SECTION 73 APPLICATION FOR THE VARIATION OR REMOVAL OF CONDITIONS ATTACHED TO PLANNING APPLICATION DC/21/06729.

LAND WEST OF ROSEMARY, CHURCH ROAD, STOWUPLAND, SUFFOLK IP14 4BG

CONDITIONS TO BE VARIED; 2, 10, 11, 14
CONDITIONS TO BE REMOVED; 4, 5, 6

Project RESIDENTIAL DEVELOPMENT AT LAND WEST OF "ROSEMARY", CHURCH ROAD, STOWUPLAND FOR WILLOW WALK HOMES LTD.			
Title PLOT 4 - REVISED DESIGN PROPOSAL			
Scale 1 : 50 & 1:100 @ A1 page size	Date OCT 2022	Revision	
Drawing No. 22023-43

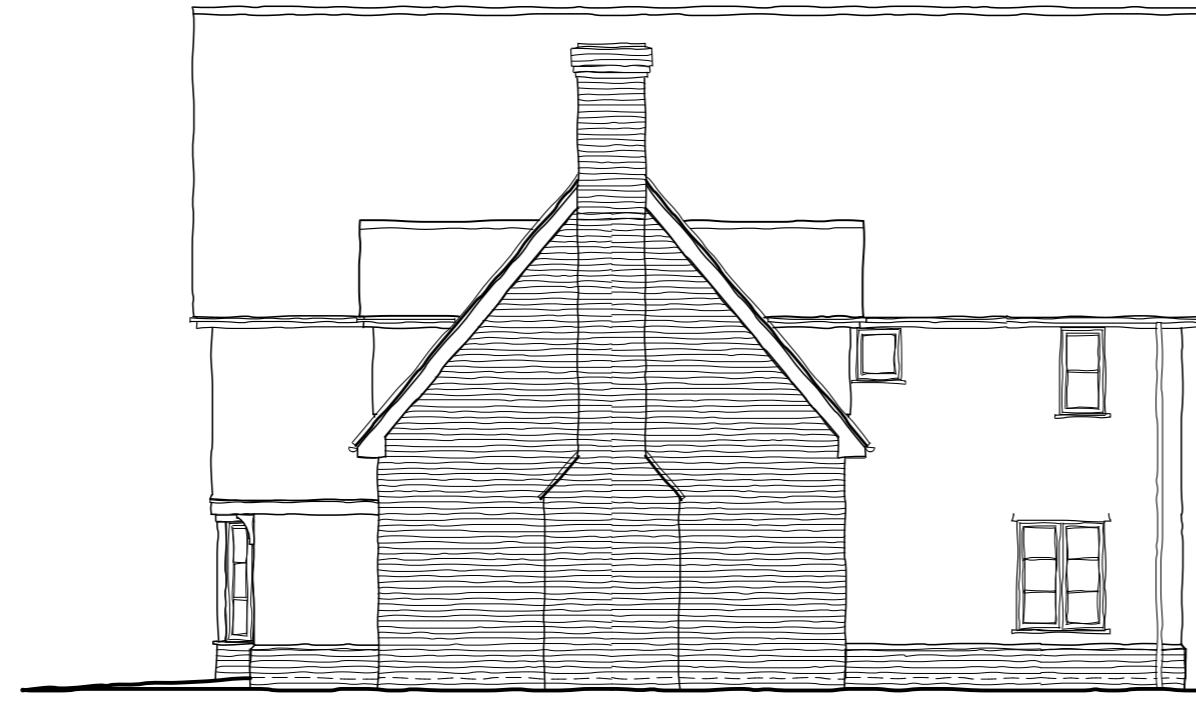
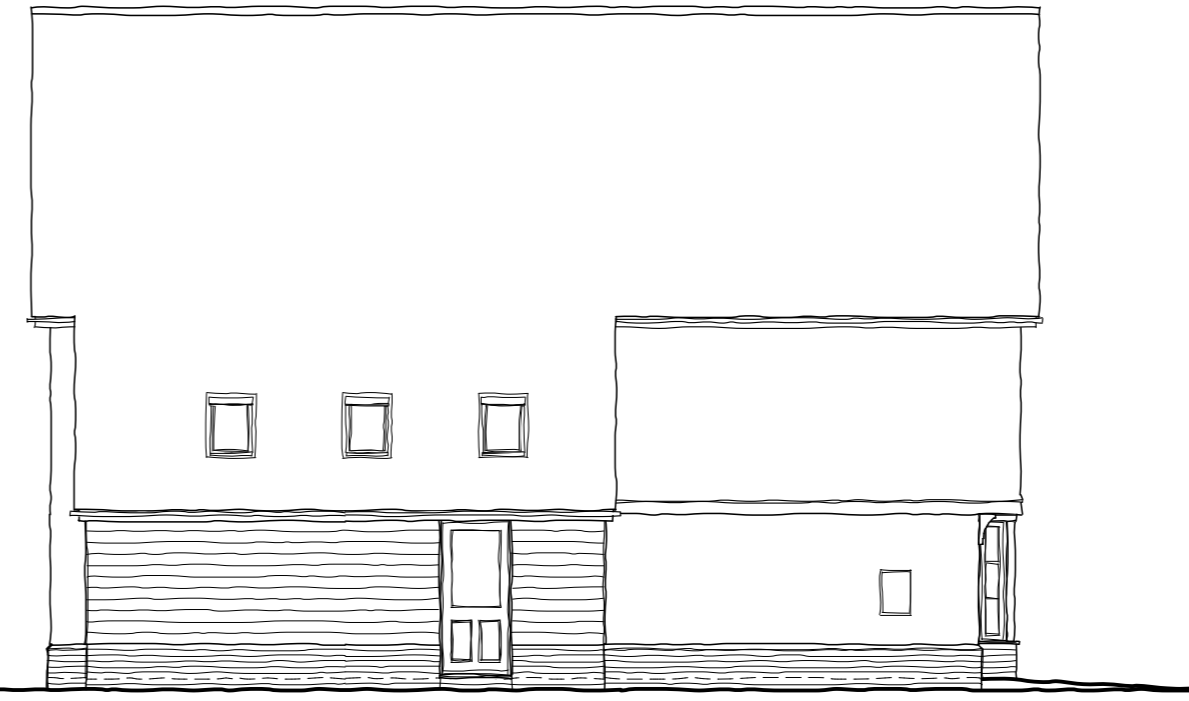
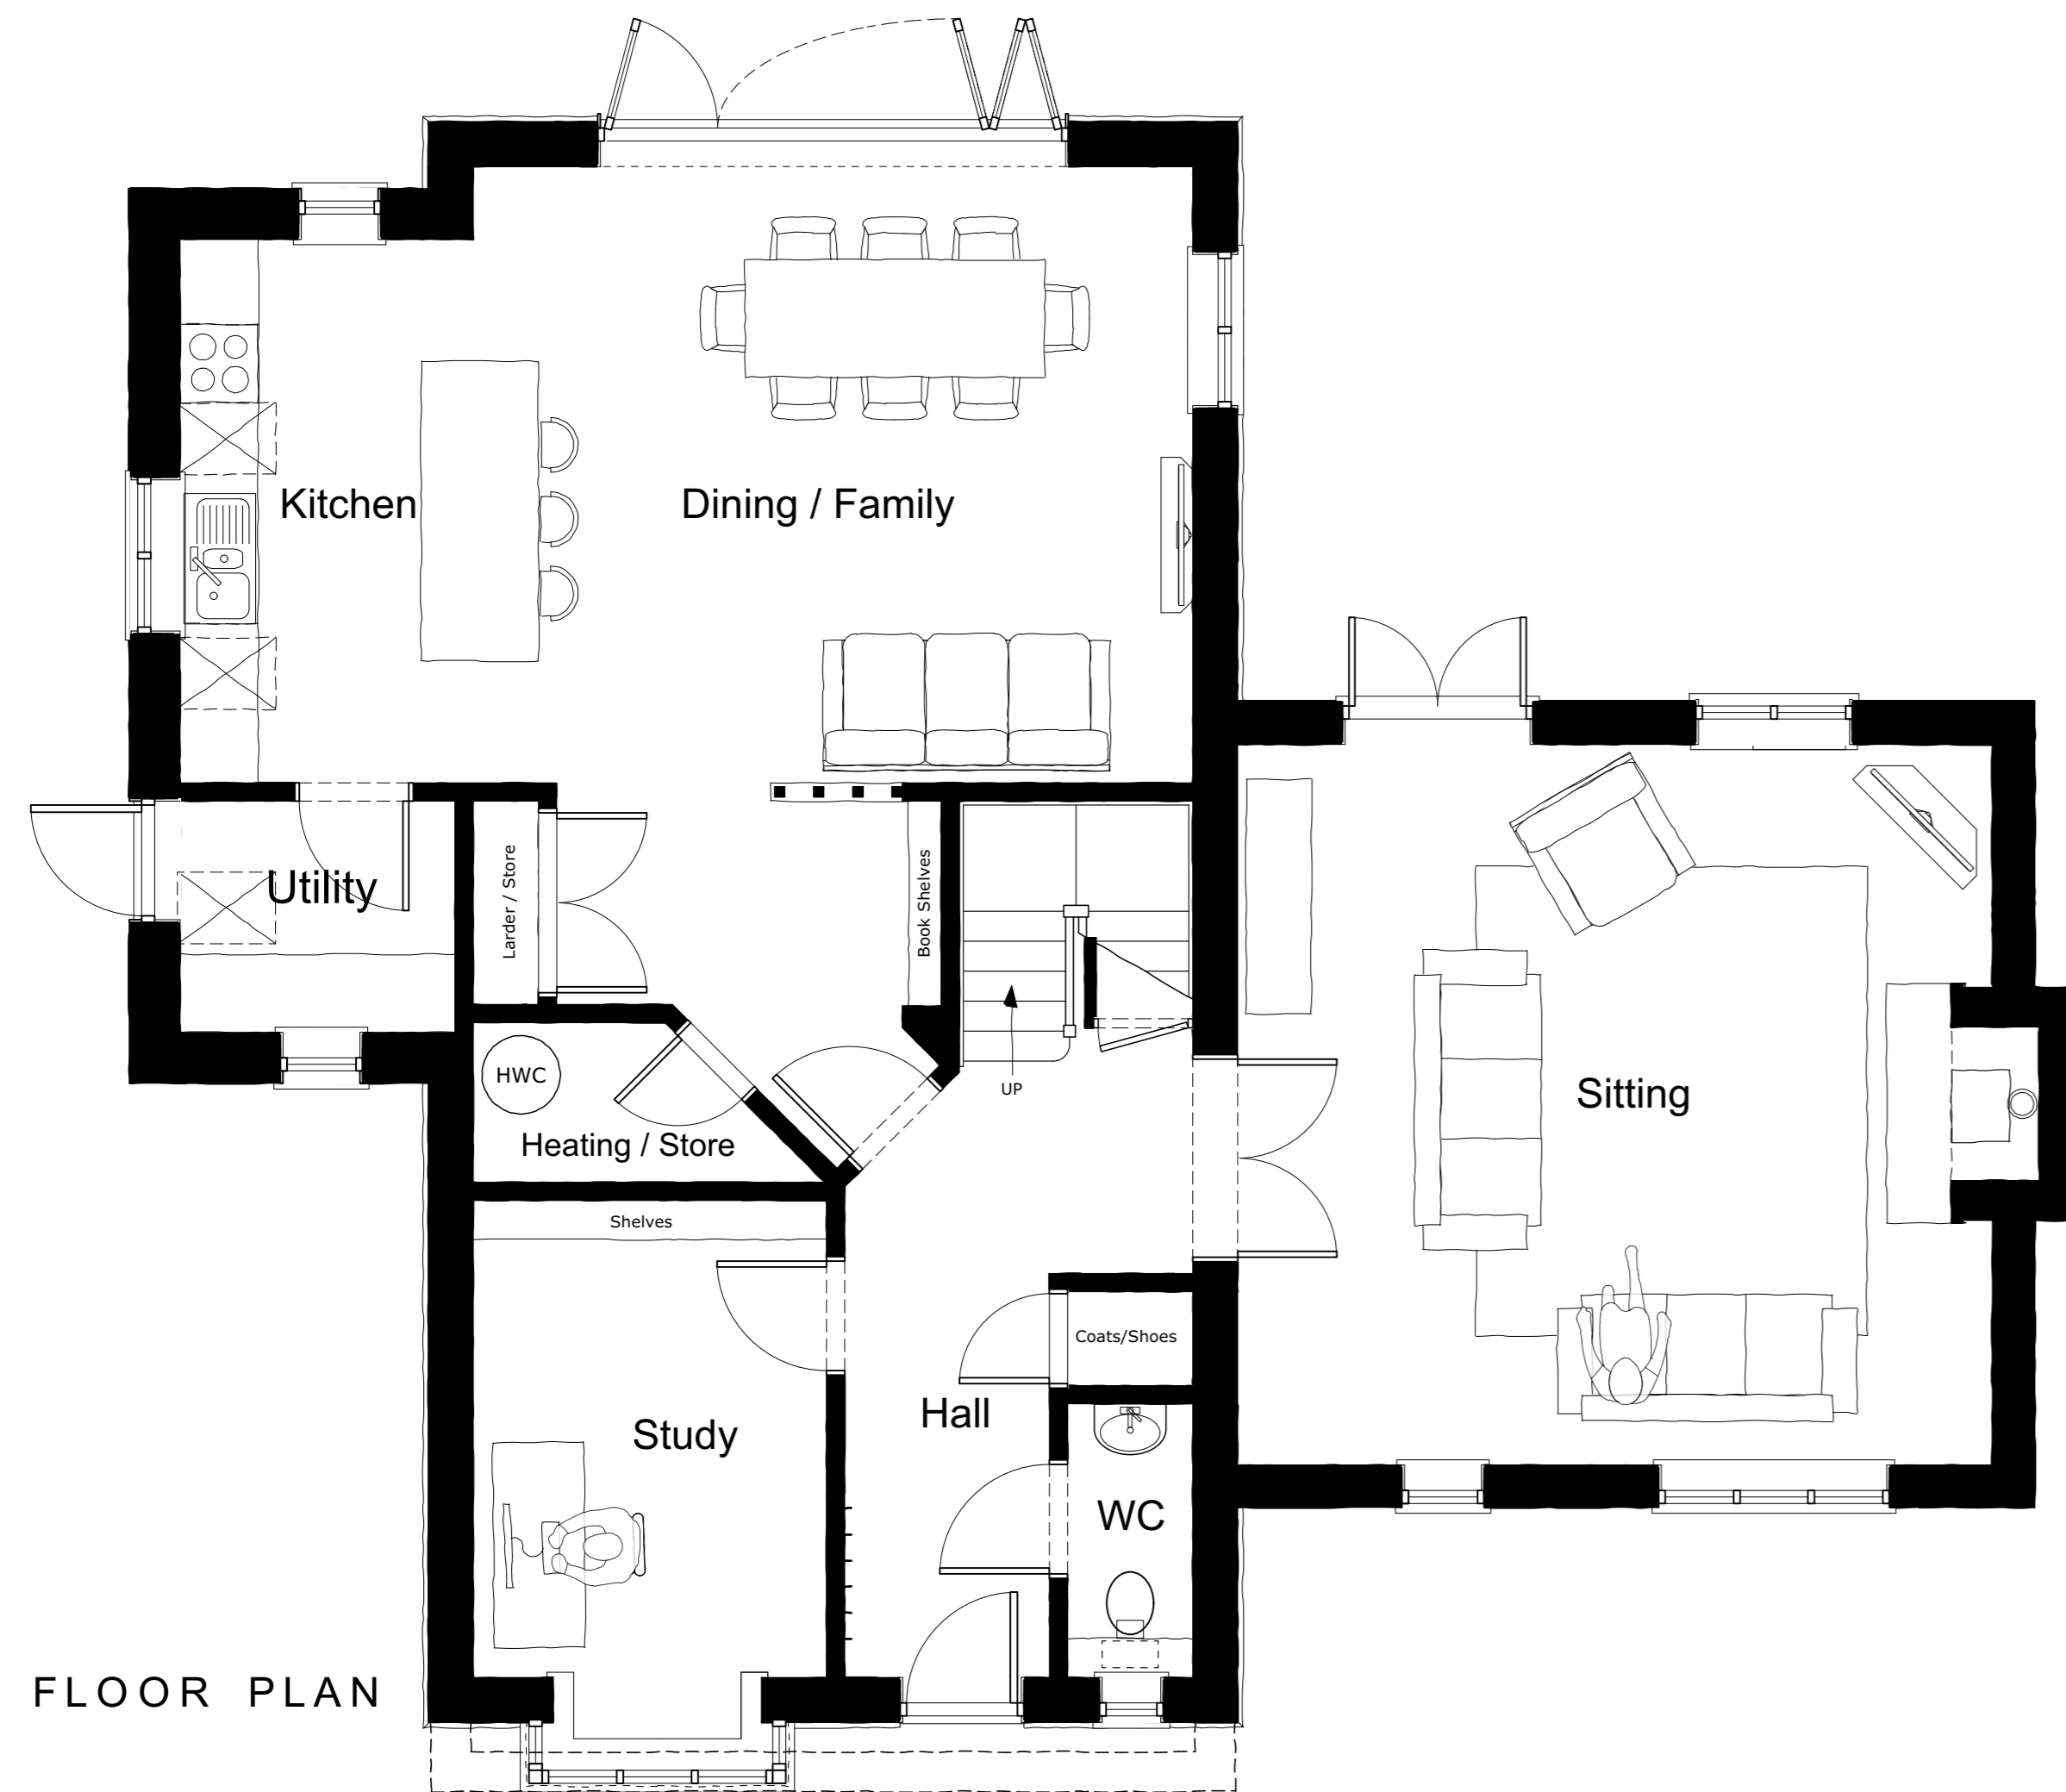
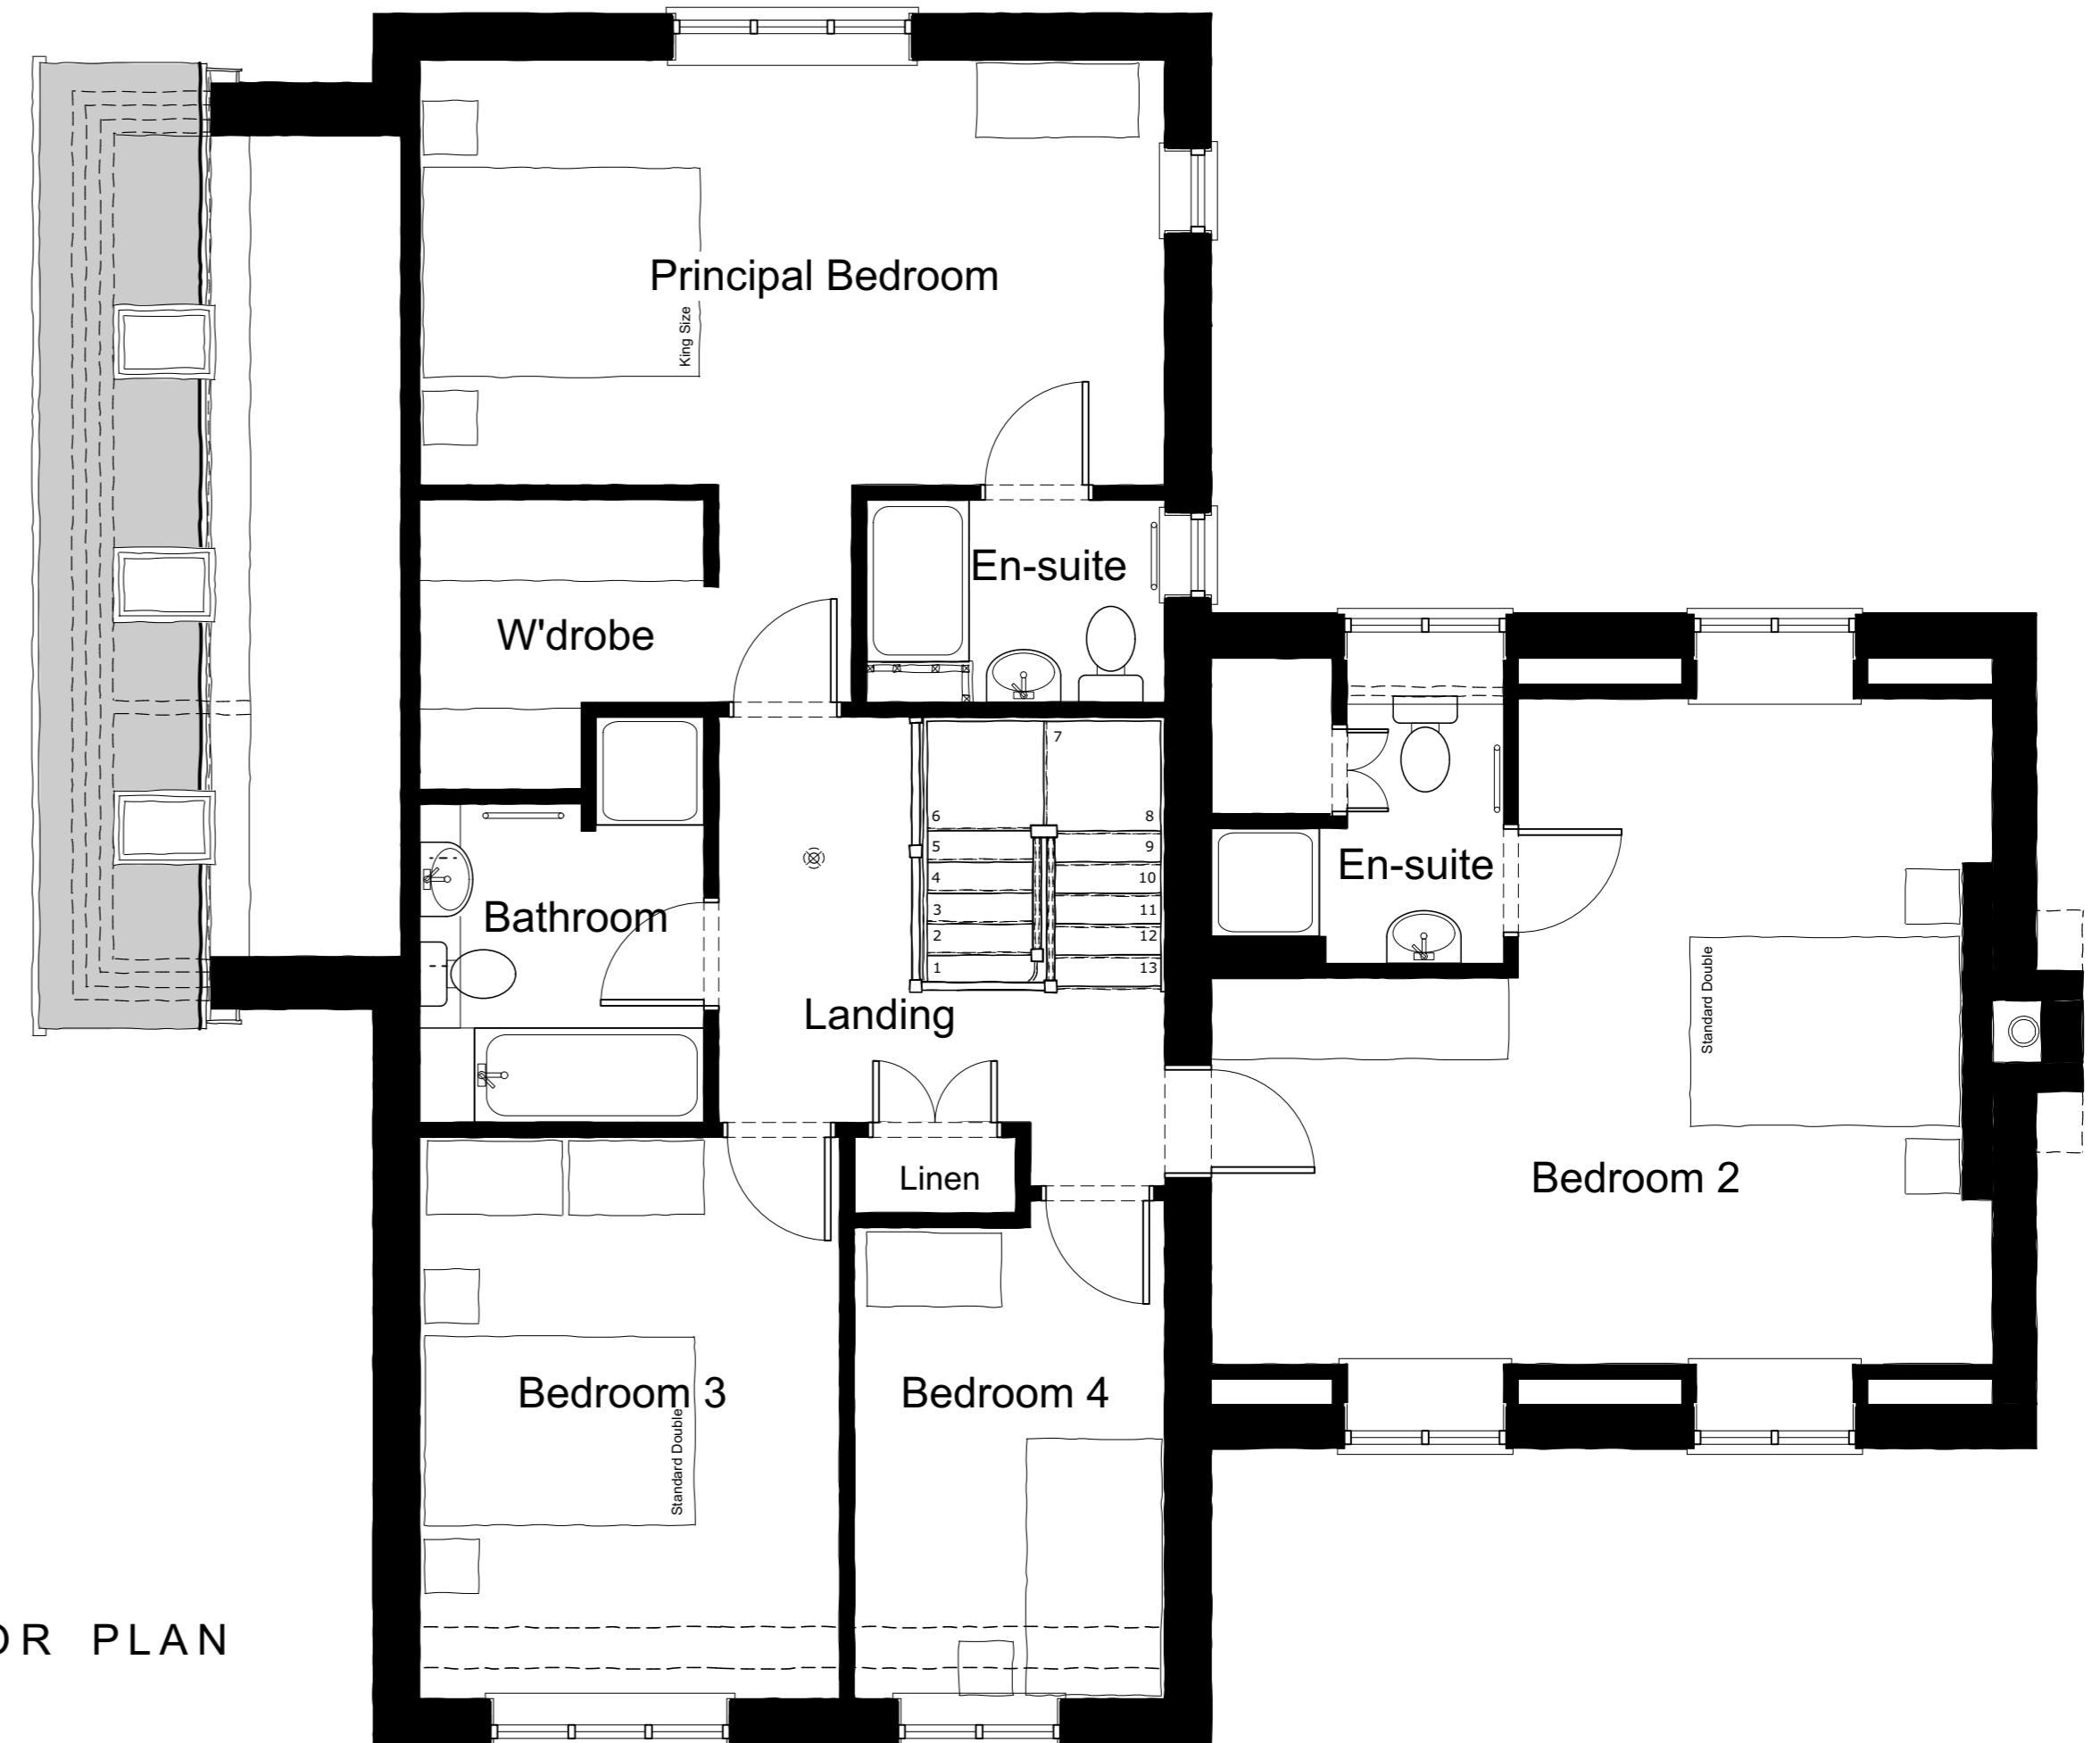
Plot 4 Floor Plans and Elevations

- Removal of the integrated garage to create a sitting room.
- Rearrangement of internal room layout.
- Relocation of chimney to the eastern gable end.
- Replacement of garage doors on the front elevation with two windows.
- Movement of side projection on the western side of the house 2.5 metres north.

The main change to Plot 4 is the replacement of the garage with a sitting room. The site plan has been amended to provide additional parking at the front of the house to compensate for the loss of garage parking space. The windows which replace the former garage doors are attractive and improve the outlook of Plot 4.
